Re: Mesa del Sol Montage Unit 4 (Project # PR-2020-003422, Application # SD-2020-00091,
Hydrology File R16D006A), Comment Response Letter

Enclosed are the responses to the comments provided on the June 17, 2020 DRB hearing.
Comments and responses are listed below by department.

@ $S = 0.5\%$
 $d = 0.65'$
 $Q_{inlet} = 7.7 \text{ cfs}$

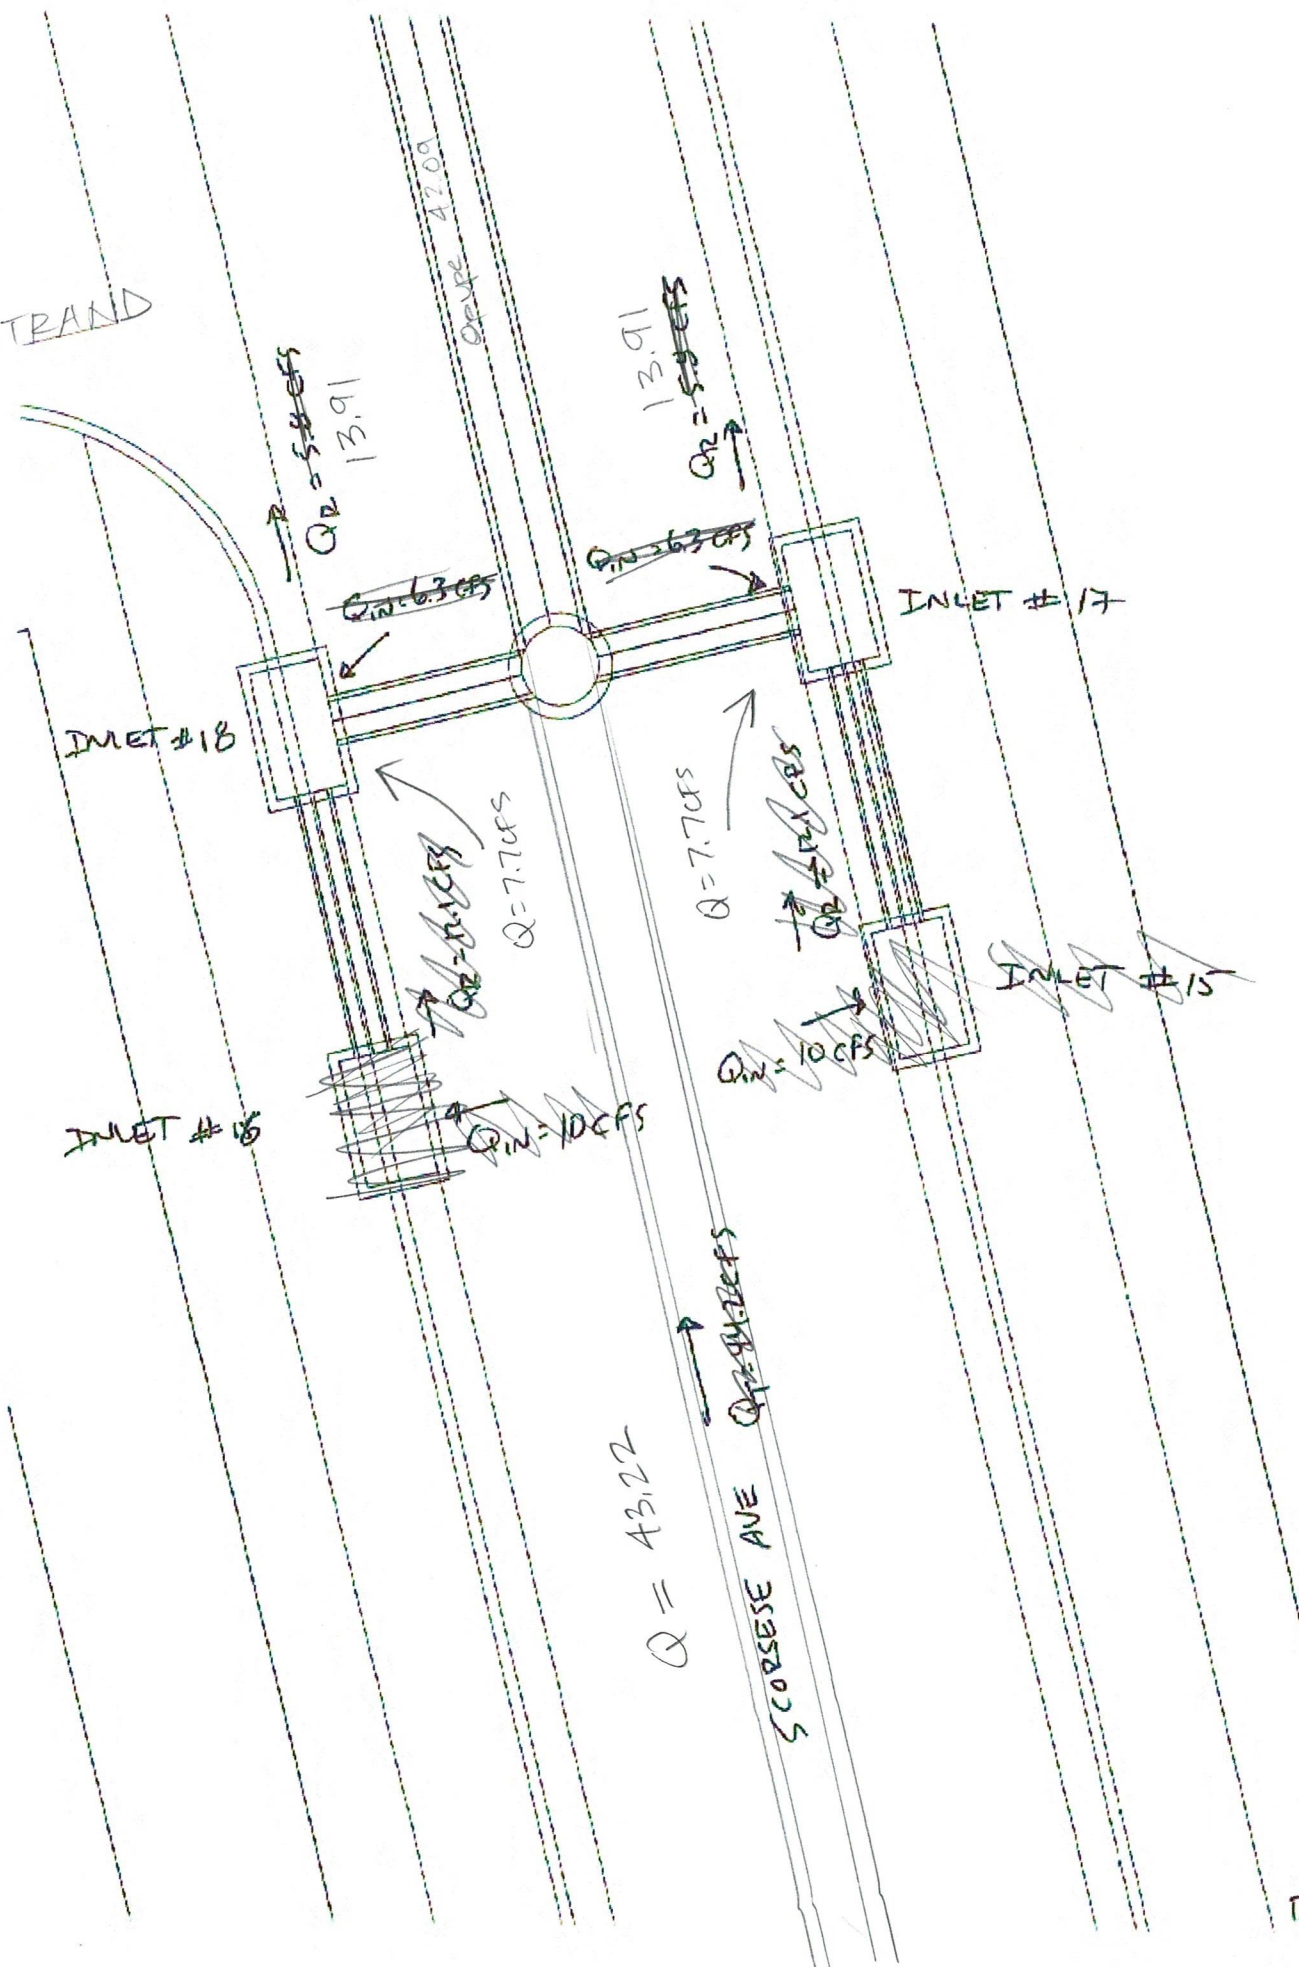
1. An approved grading plan and drainage report is required.
Response: A revised grading and drainage is submitted concurrently to this submittal.
2. In the Amended Drainage Report on pages 30,32 and 36 for inlets on Dekooning and Sagan, please size/type of inlet being analyzed. All previous sections listed this information,
Response: Completed. See attached Revised Drainage Report

Drawing file: Application / 2B.  Pre-plat MDS Montage Unit 4_SIGNED.pdf

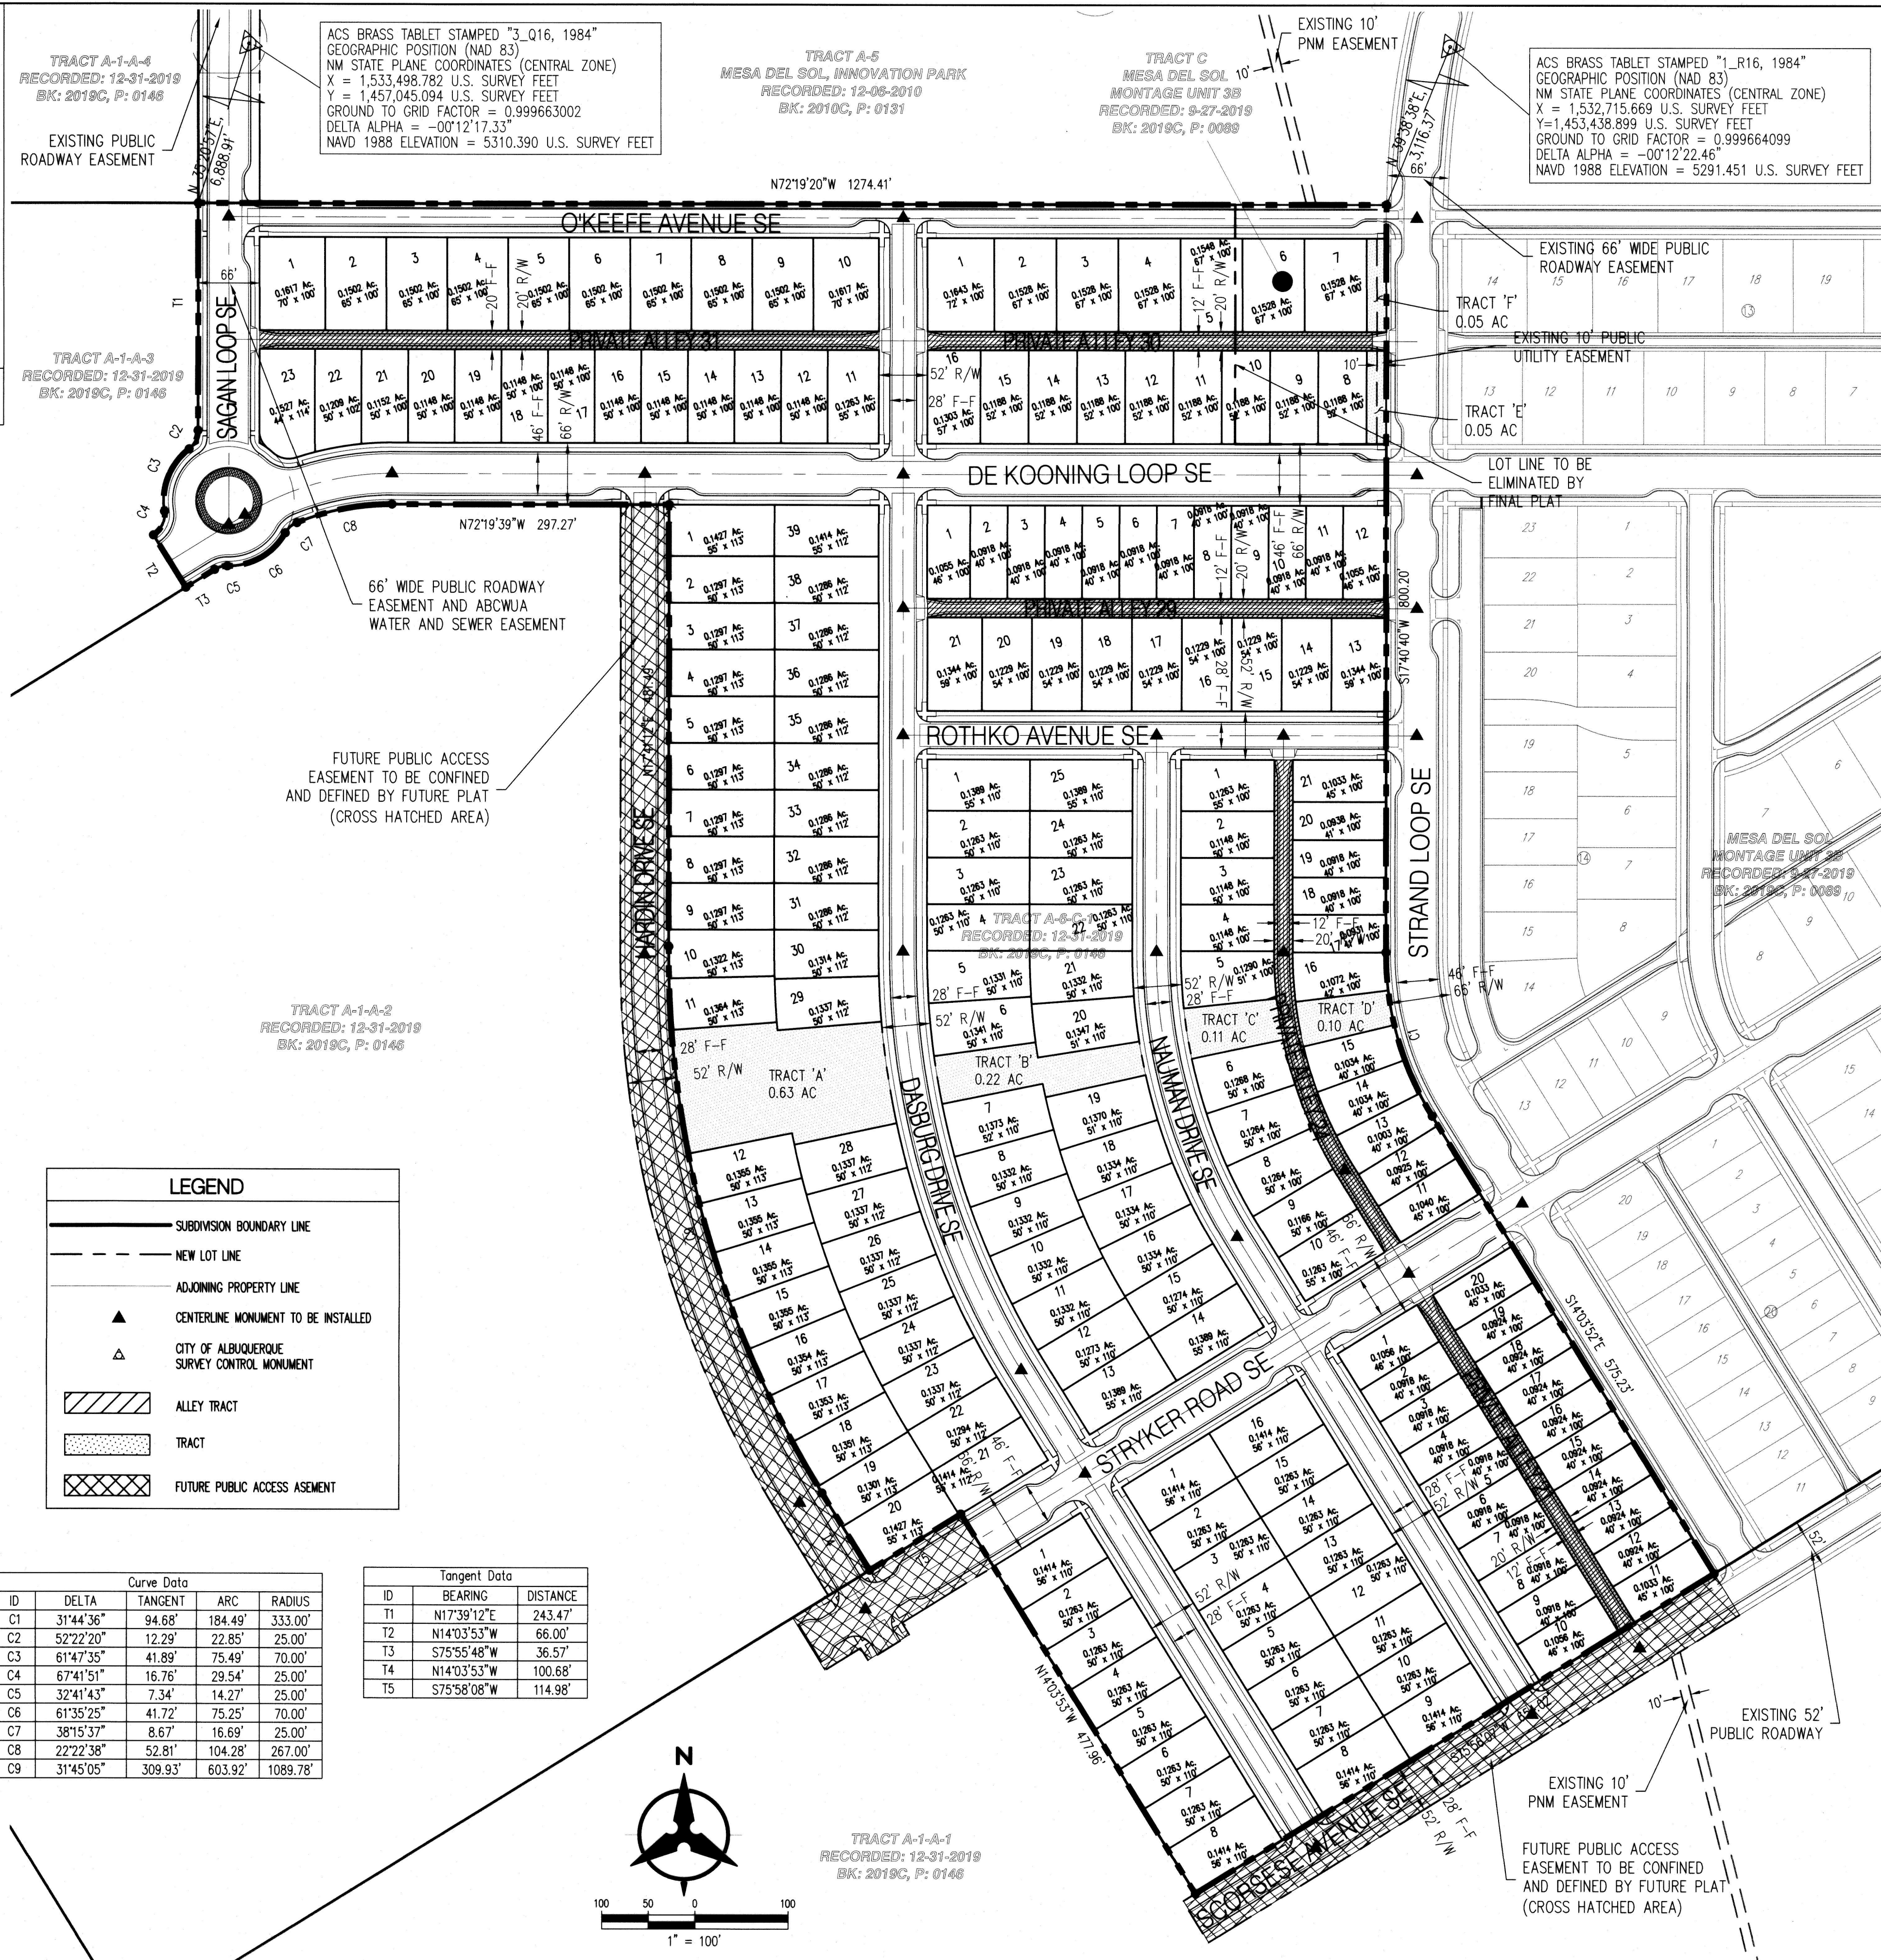
1. Street layout must be consistent with the Mesa del Sol level B Masterplan, see section 3.1. A recorded infrastructure improvements agreement will be required prior to final plat sign off Future development must be consistent with the Mesa del Sol level B Master plan.

Response: The plan is consistent with the Level B Master Plan. Please See attached Preliminary Plat, and Revised Infrastructure List
